**OBJECTION**

**State Significant Development Application No: SSD-10300**  
**Coffs Harbour Cultural and Civic Space**

GORDON ST ELEVATION

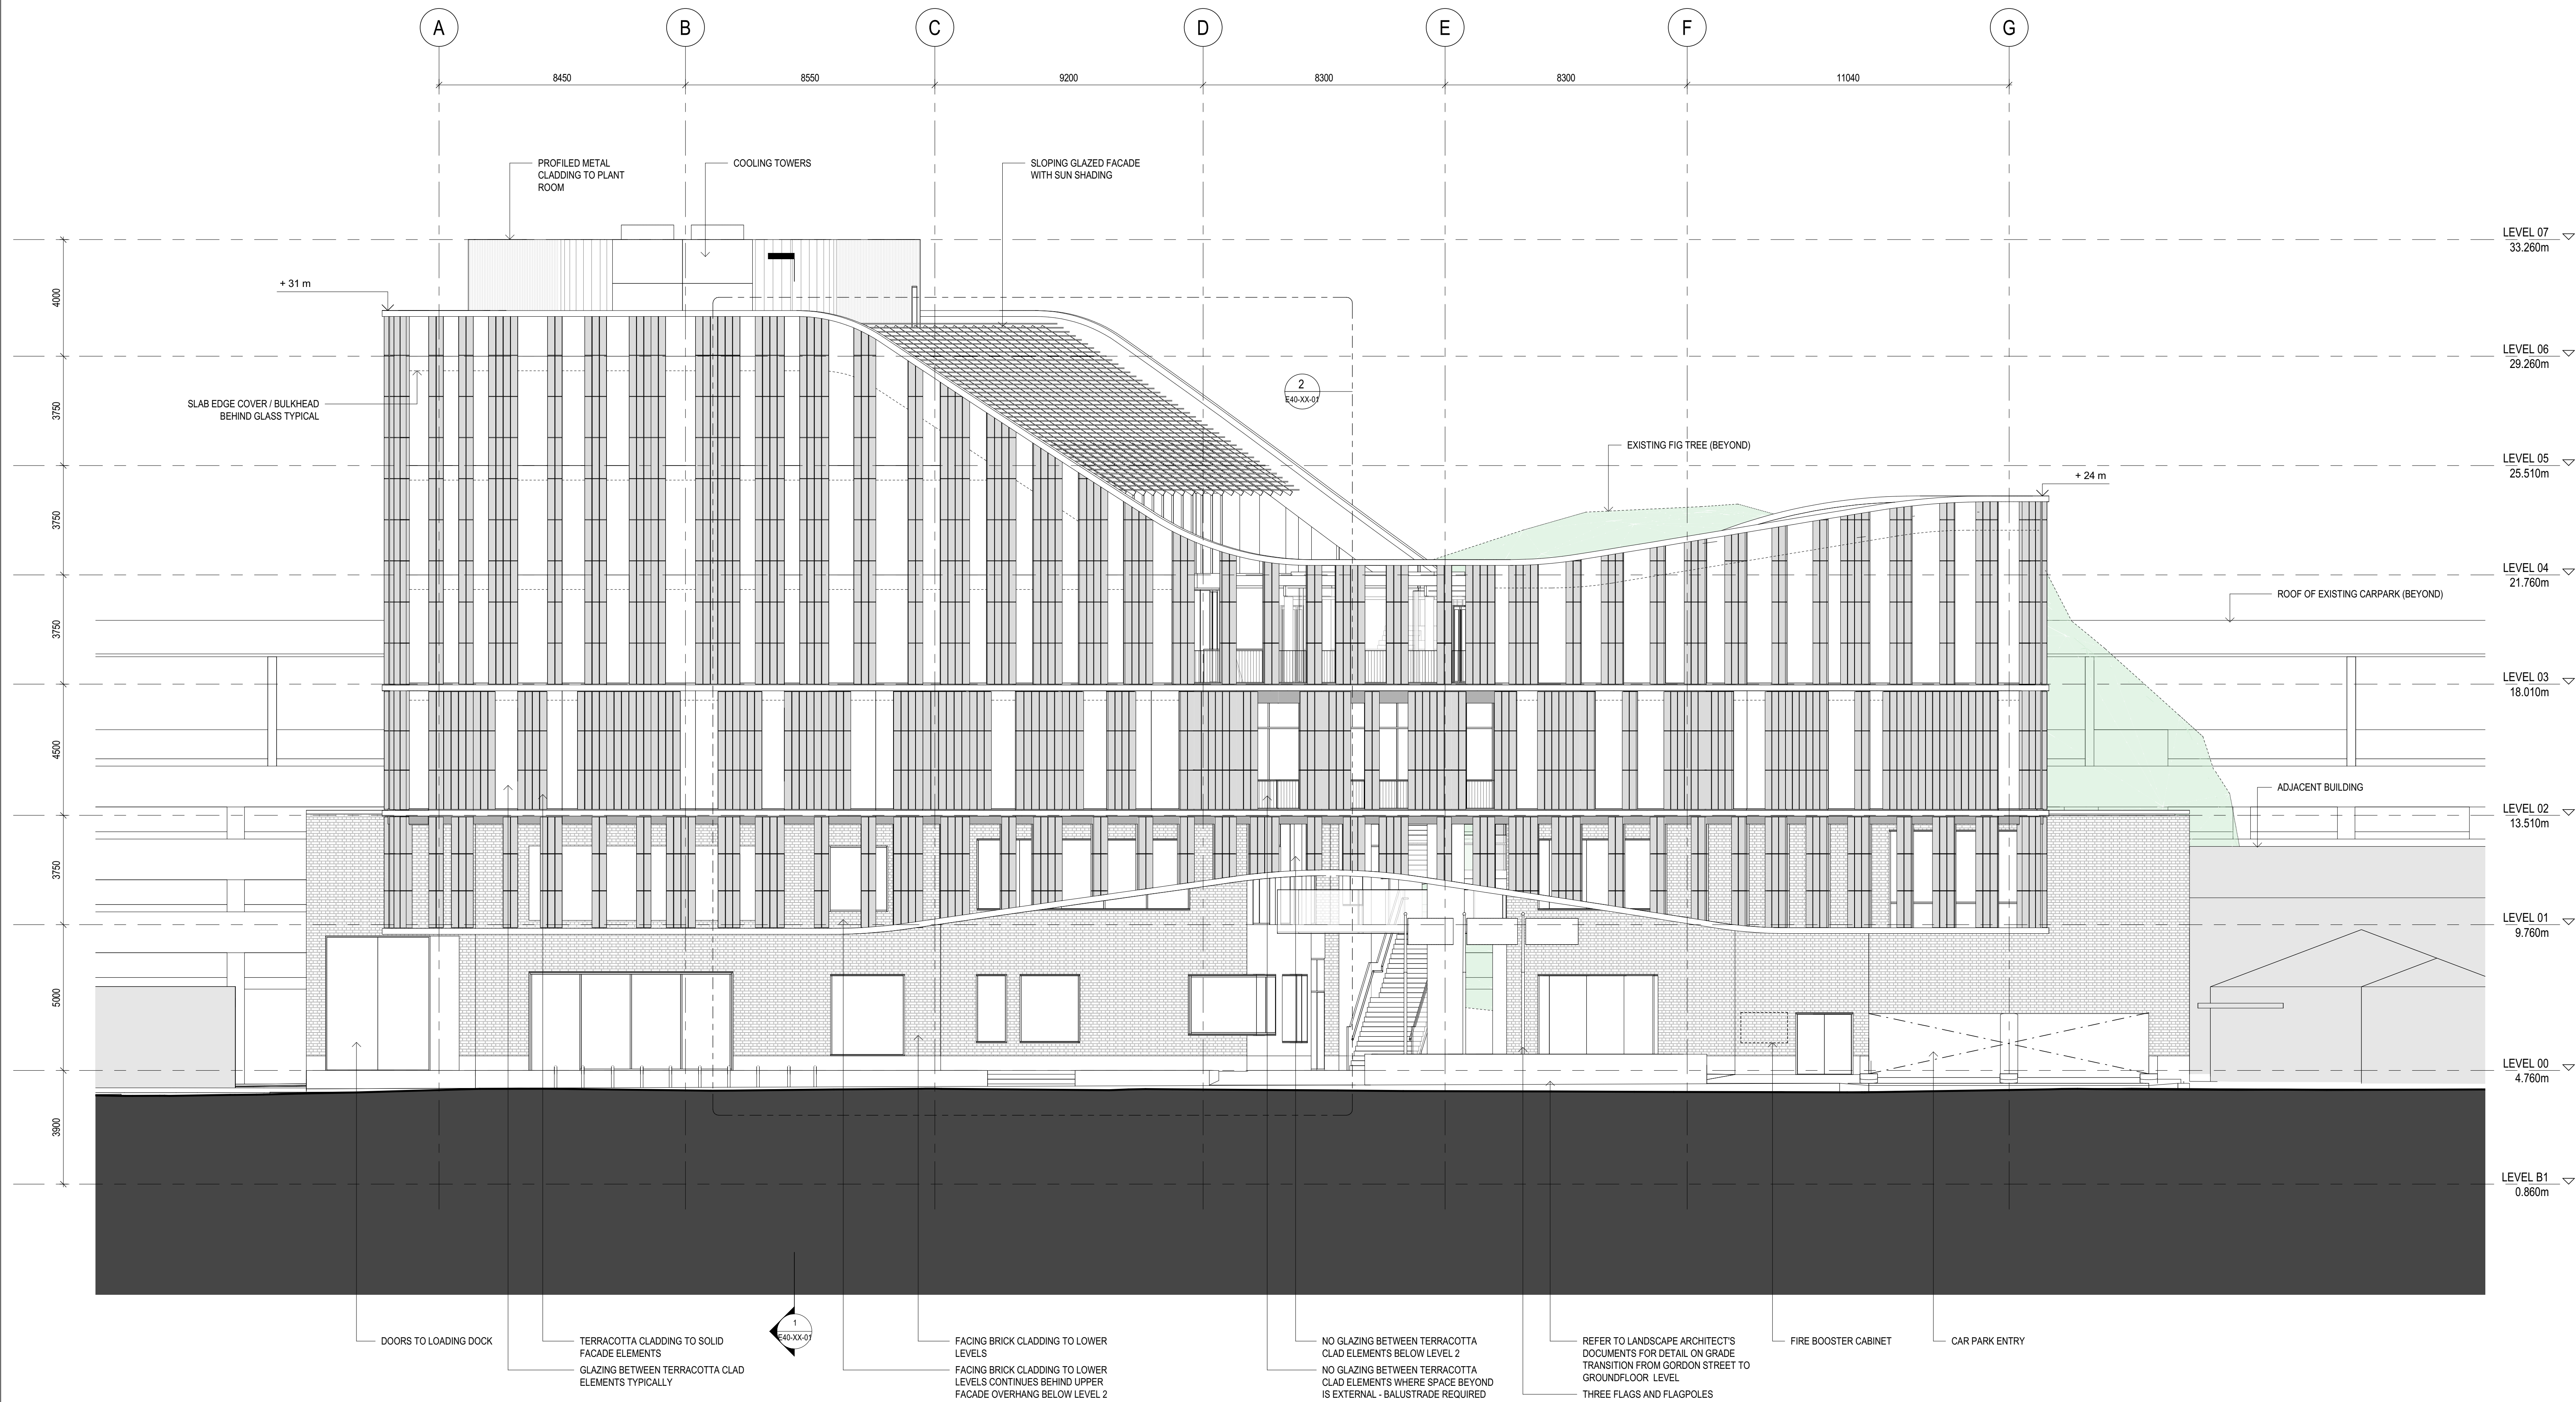
5. The proposed building is out of context in the street with no regard to scale, existing street setbacks, design and general form of adjoining buildings.

SECTION N-S

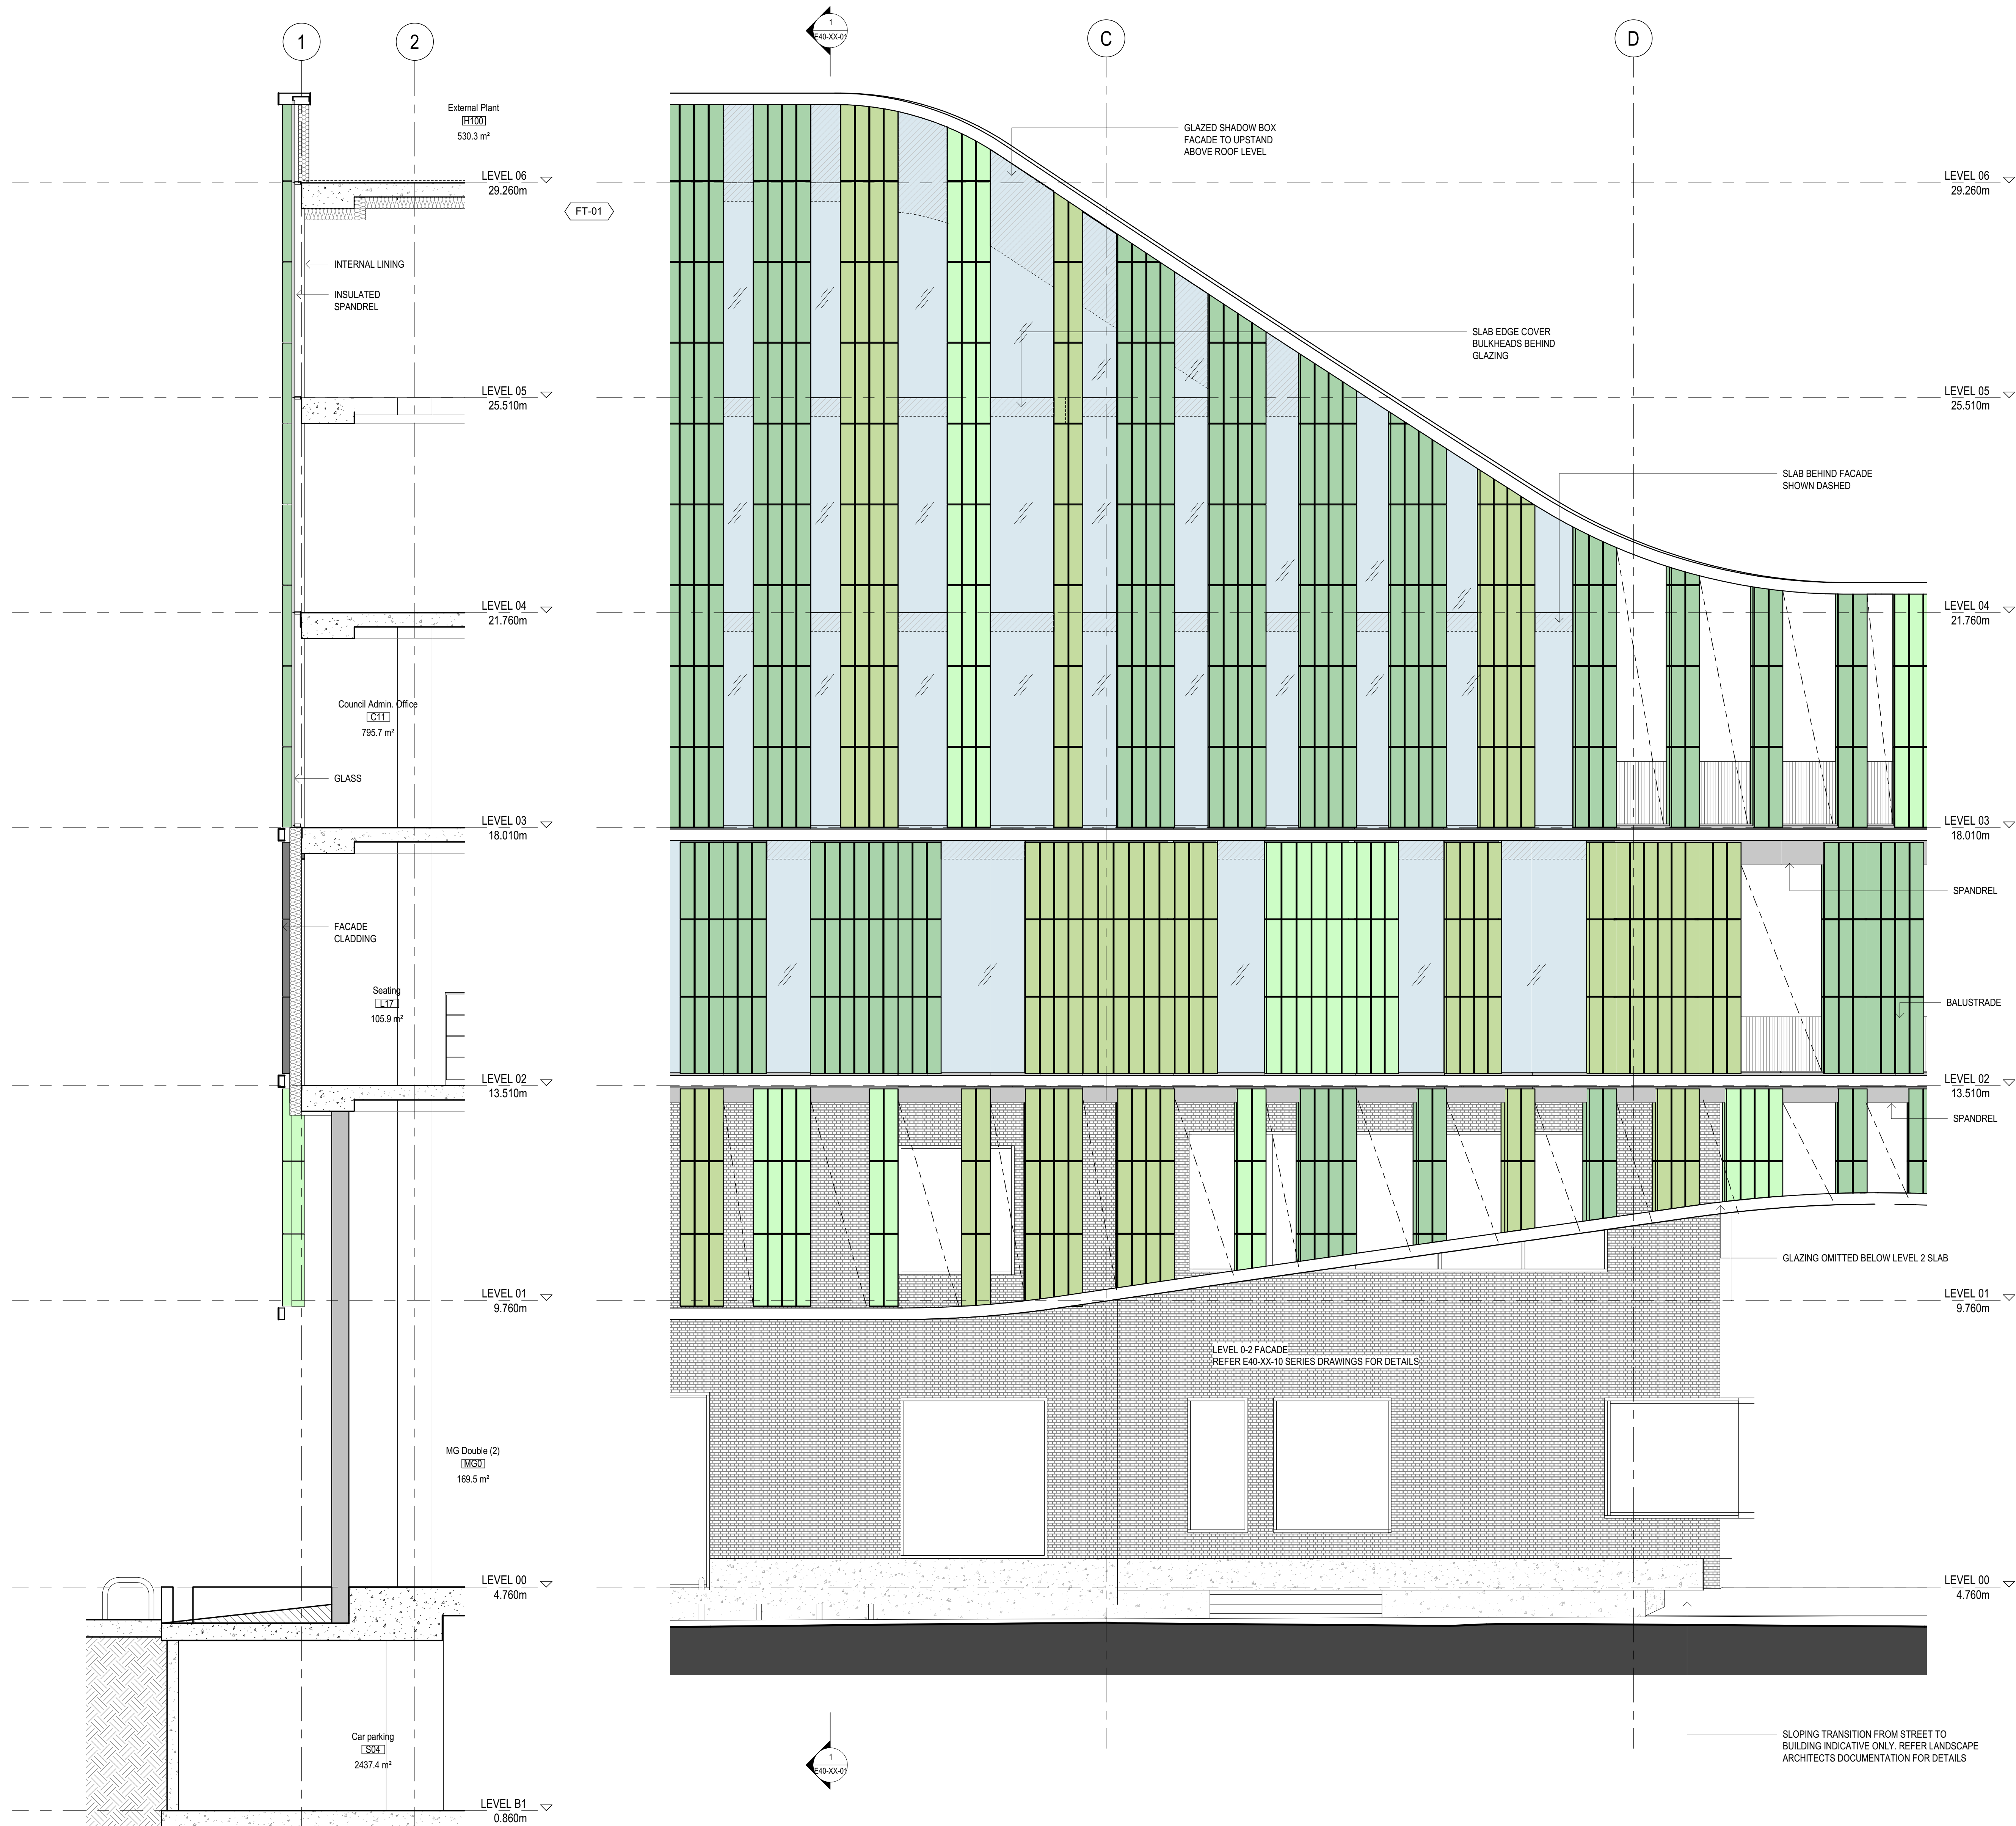
7. As a public building it fails to provide sufficient climate protection for pedestrians during storms and summer sun.
8. The building exceeds the height restriction of 28m set down in Council's own planning controls. Council's argument for variation is not satisfactorily justified and is not consistent with the objectives of the Environmental Planning and Assessment Act 1979, which requires the "the orderly and economic use and development of land". Council should not receive preferential treatment.
